## 300 Fore Street - Permit Status

A00.101

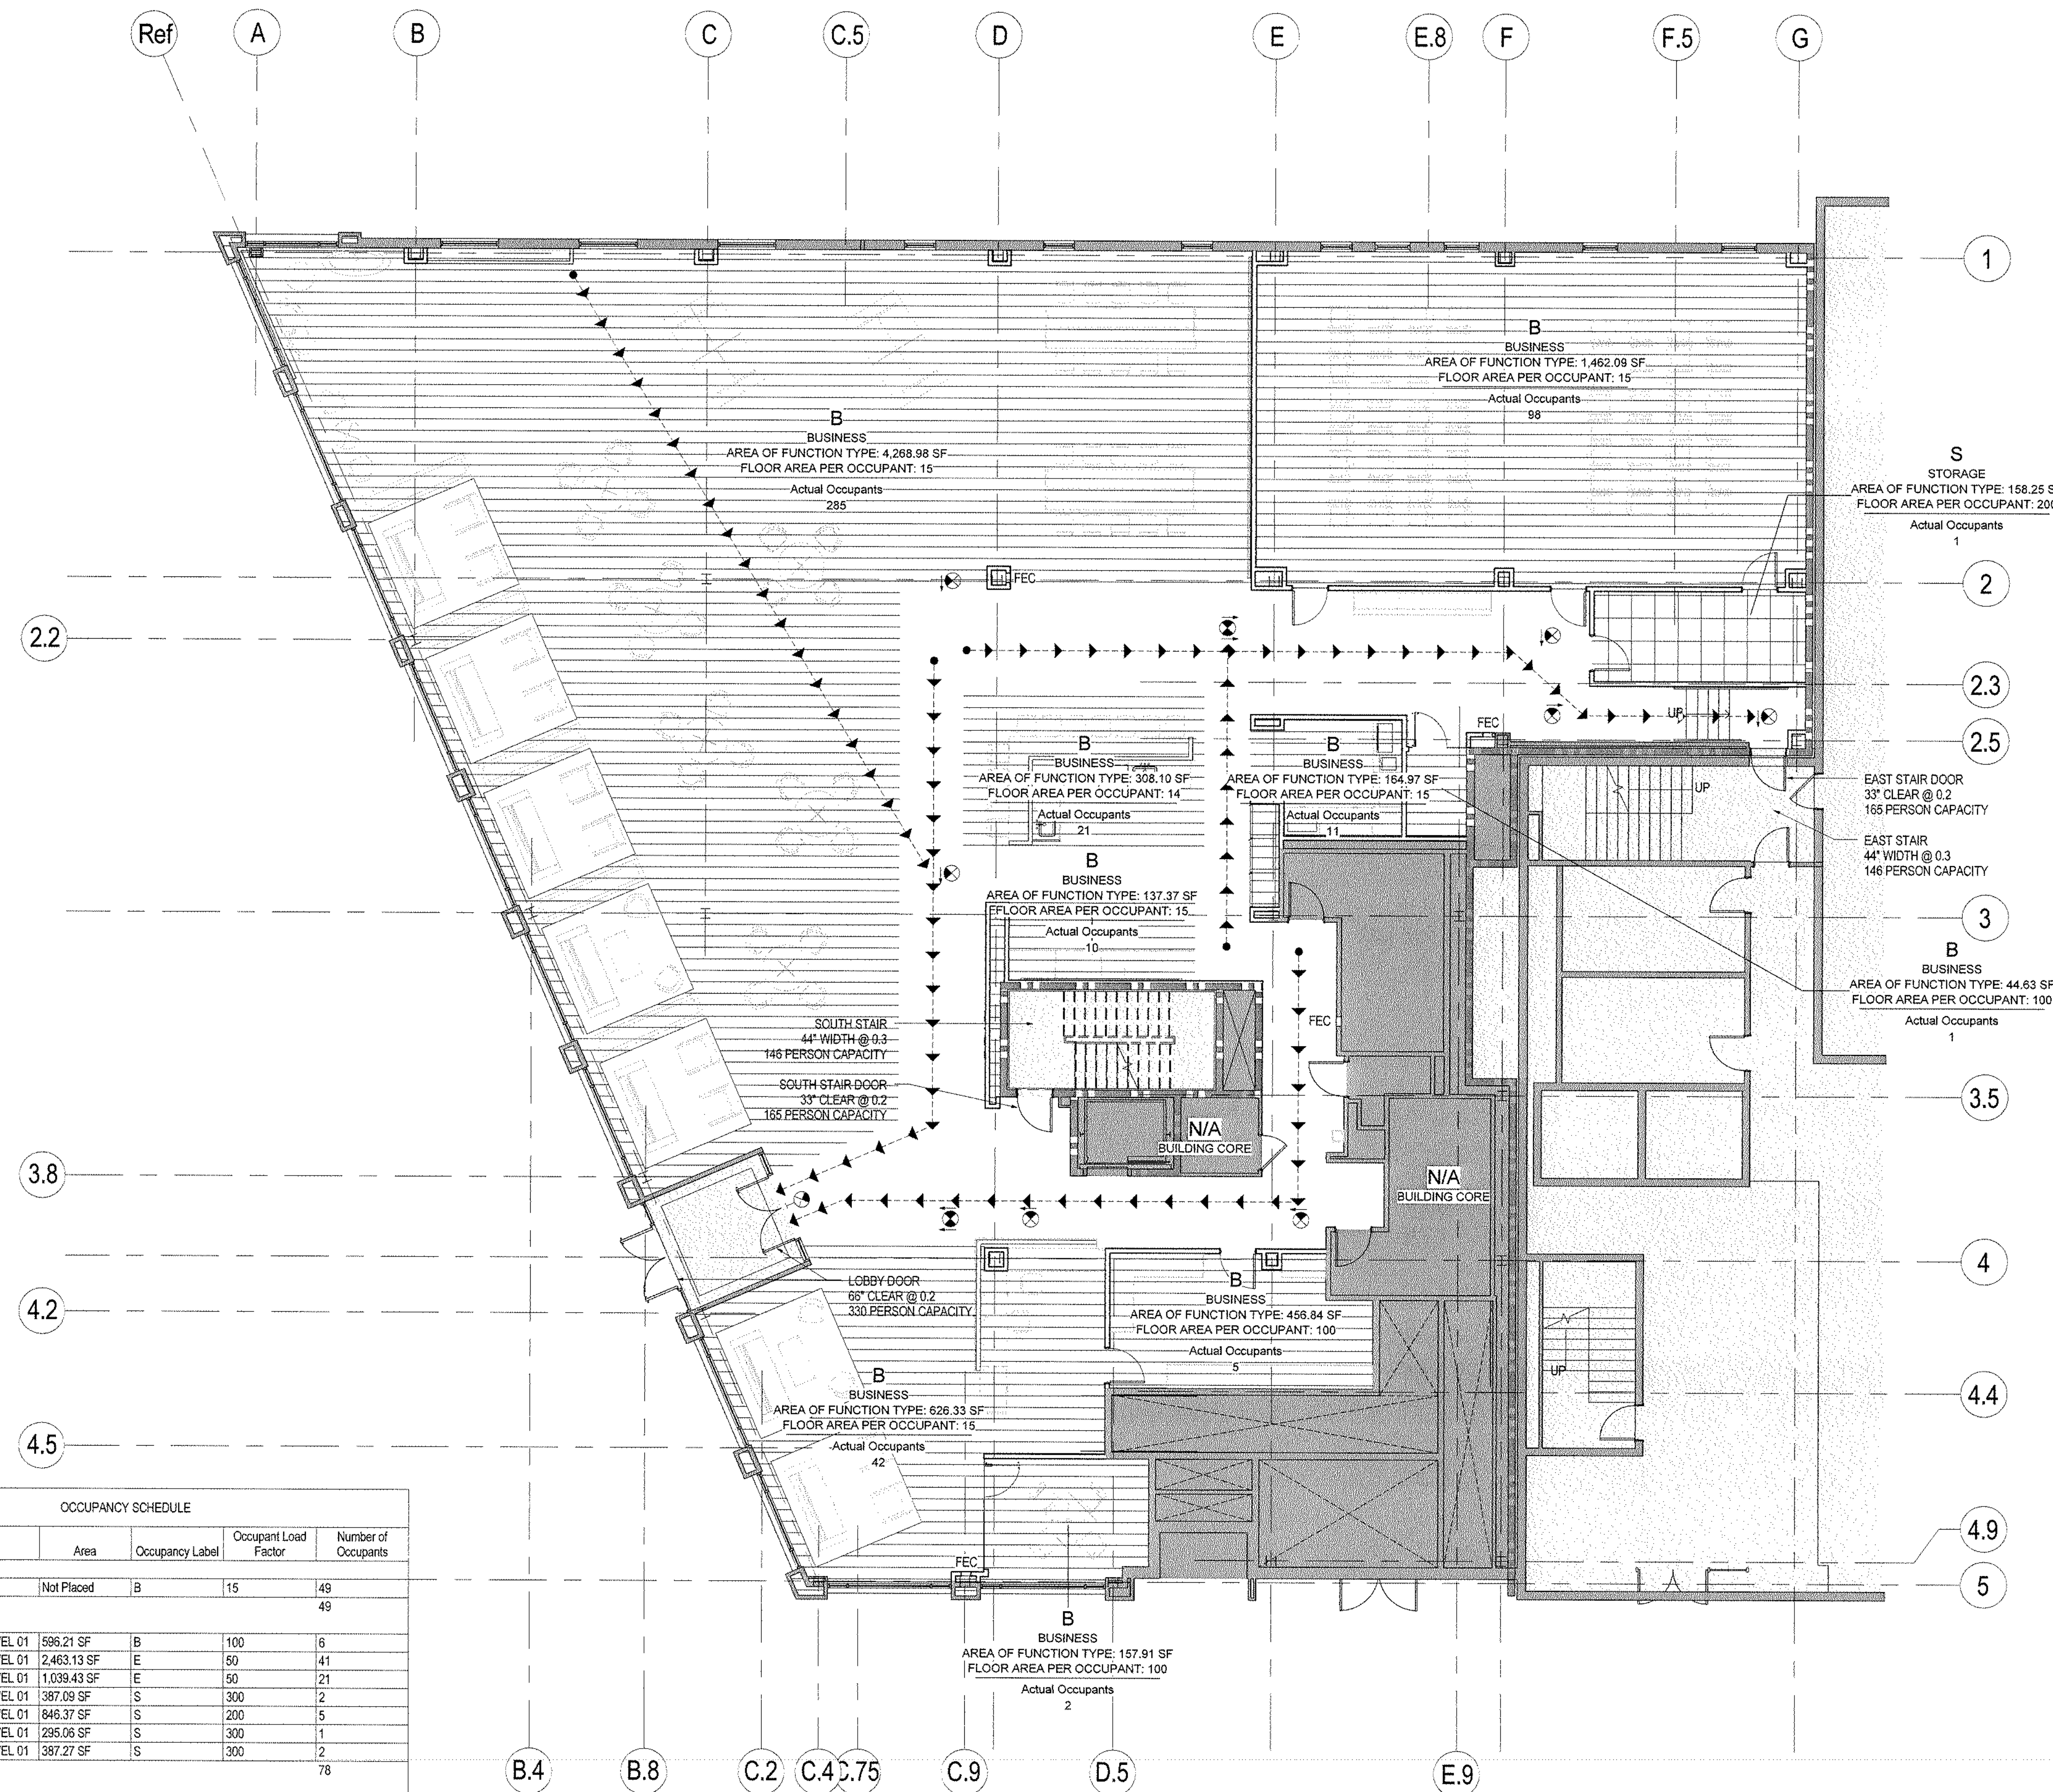
Regarding Jeanie's inquires on the shared stair on the plan east side of the Life Safety drawings, the stair and corridors in question are outside this project scope. That said, Anthony forwarded everyone some notes and pictures of the existing conditions. It appears that those spaces are common core areas separate of CIEE's space and have existing exist signs.

I checked out the stairwell and related signage in question and here is what I found.

On the basement floor of the stairwell, there is an exit sign that is suggesting occupants use the egress route through 7 Custom House, rather than using the egress that is through 300 Fore Street. This is suggested once again, just outside the stairwell in the 7 Custom House building side.

On the second floor, there is an exit sign above the door leading from the 2<sup>nd</sup> Floor 300 Fore Street side and one above the door leading from 7 Custom House Street side.

A02.600

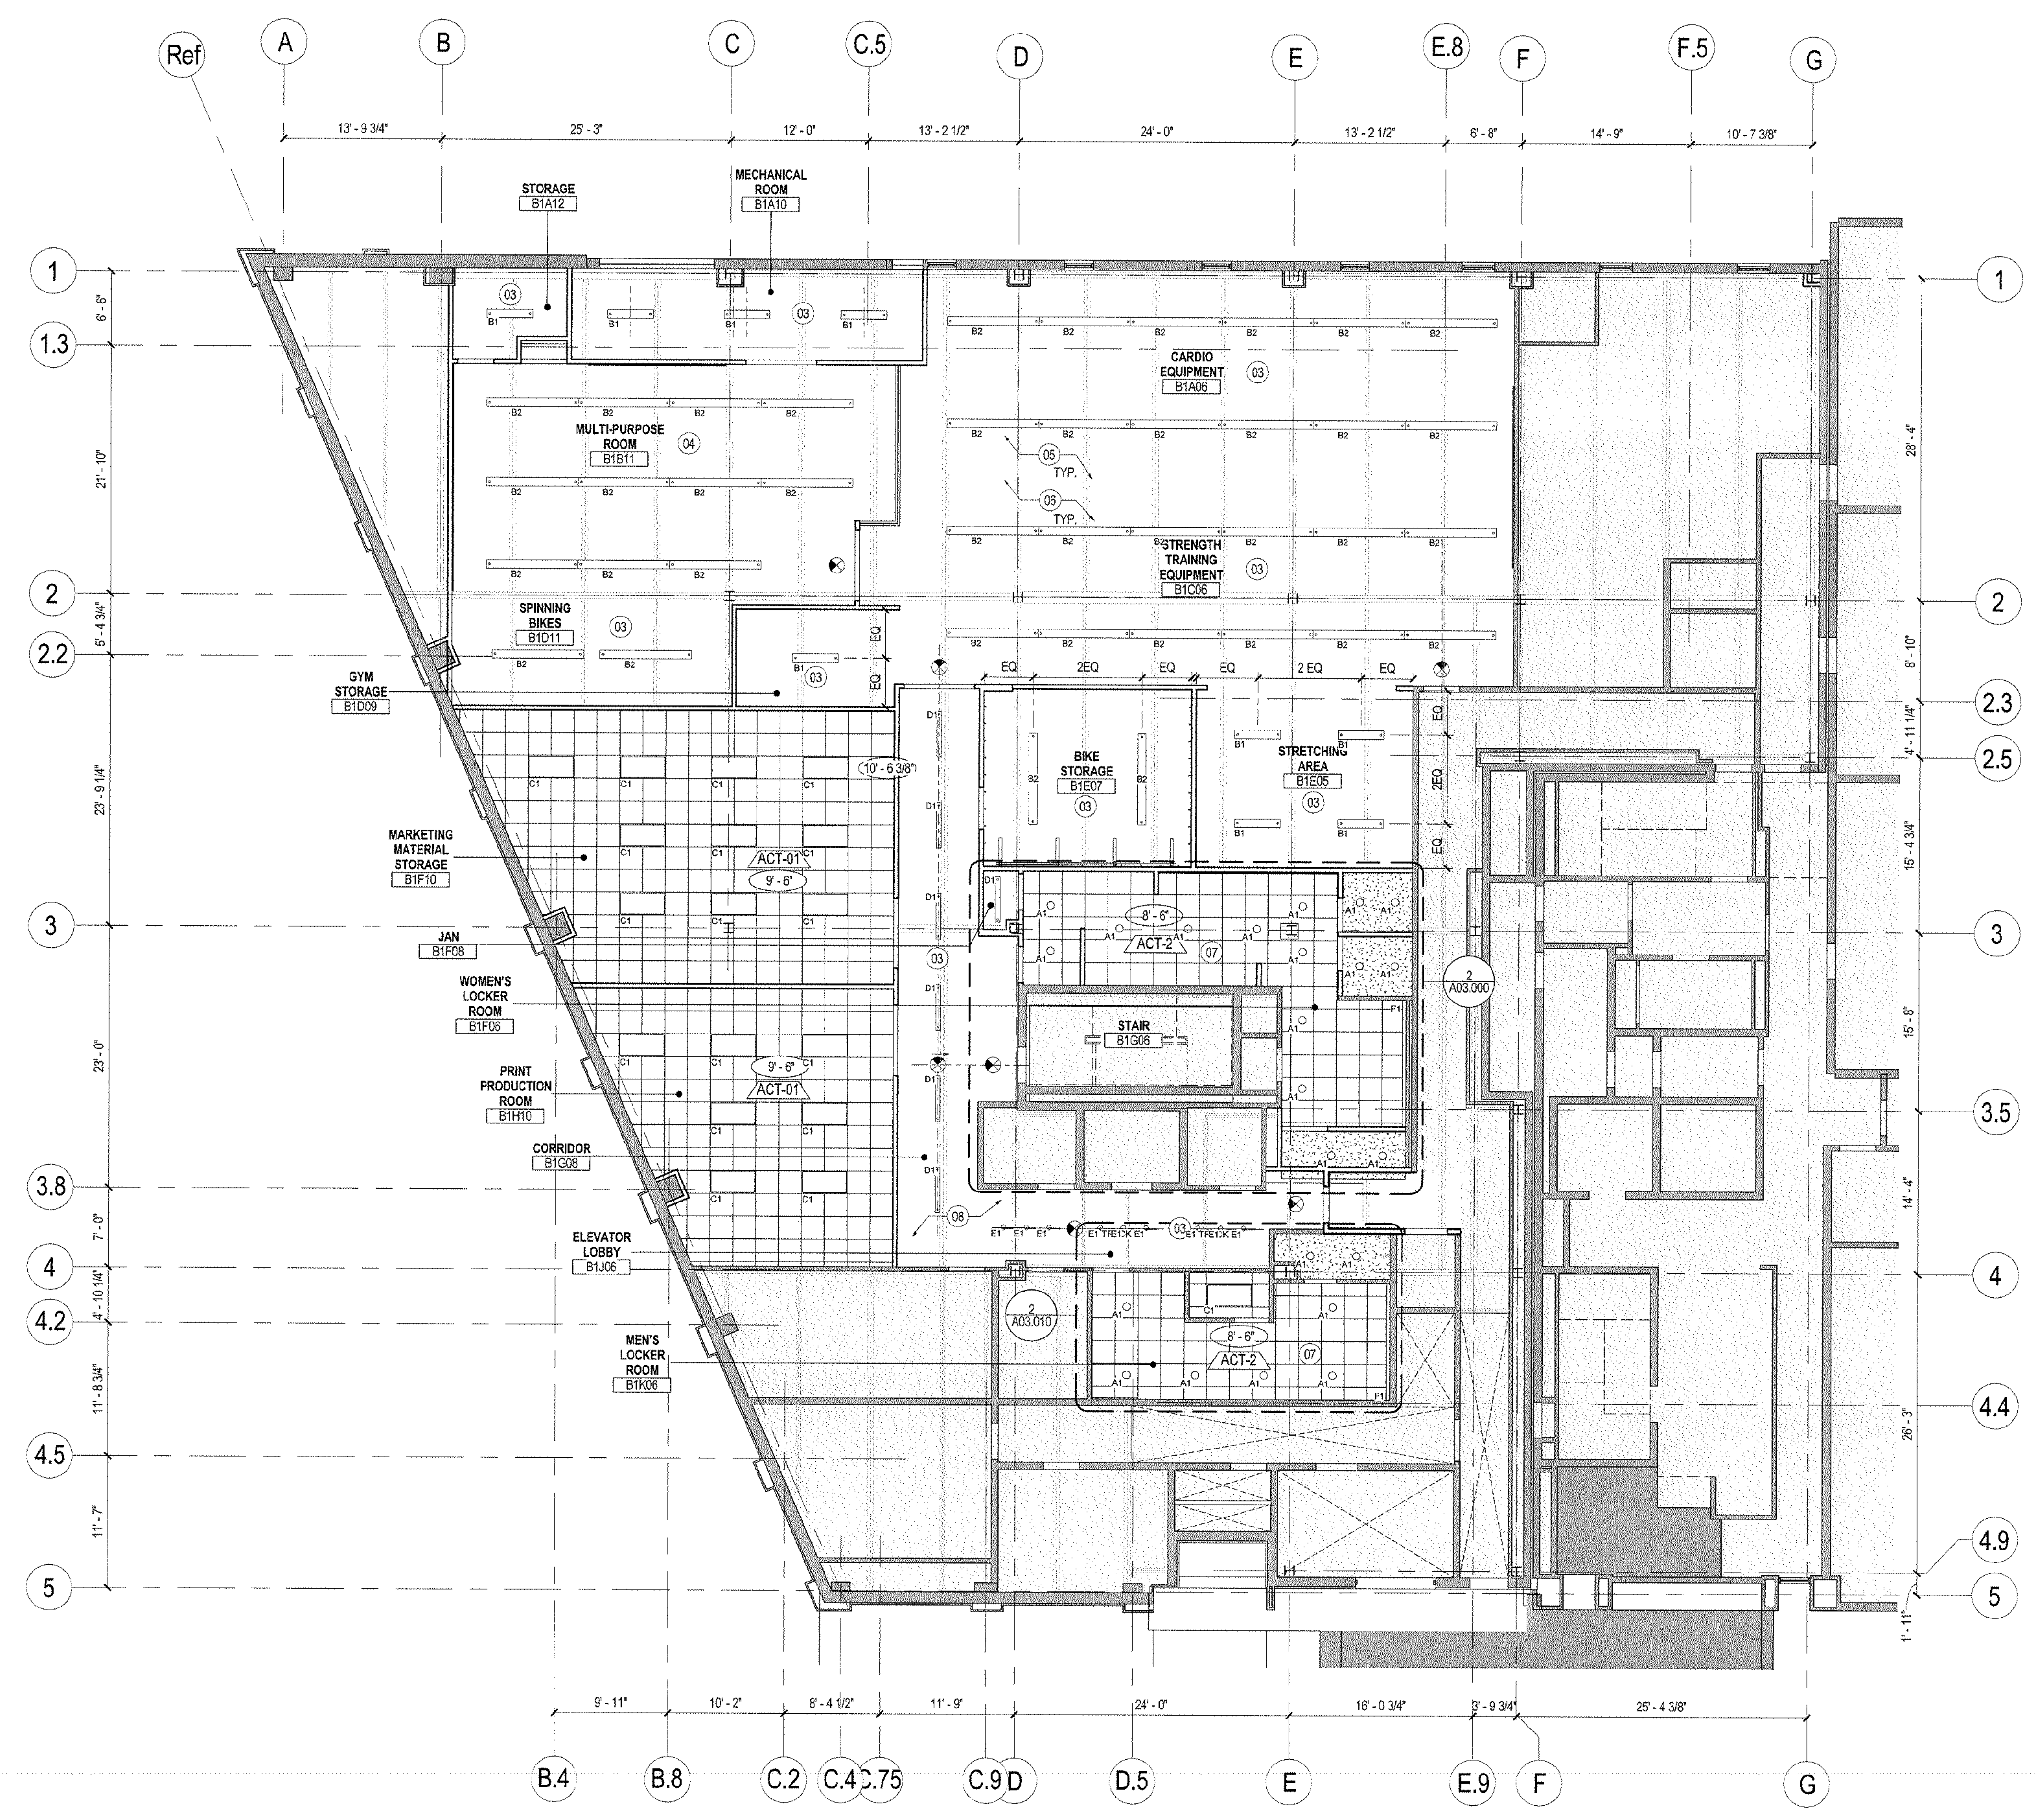
Regarding the inquiry on the egress discharge exception 1.2. This issue is regarding 2009 IBC 1027 that requires "*The entire area of the level of exit discharge is separated from areas below by construction conforming to the fire-resistance rating for the exit enclosure.*" Then for reference, per 2009 IBC 1022, "*Exit enclosures shall have a fire-resistance rating of not less than 2 hours where connecting four stories or more...*". We have reviewed the level below the proposed exit discharge on as-built drawings and the existing ceiling / floor assembly was constructed per UL D216 which has an applicable 2 hour rating. Therefore the basement areas that are to undergo construction / modifications should be reconstructed with a UL D216-2 hour rated assembly.
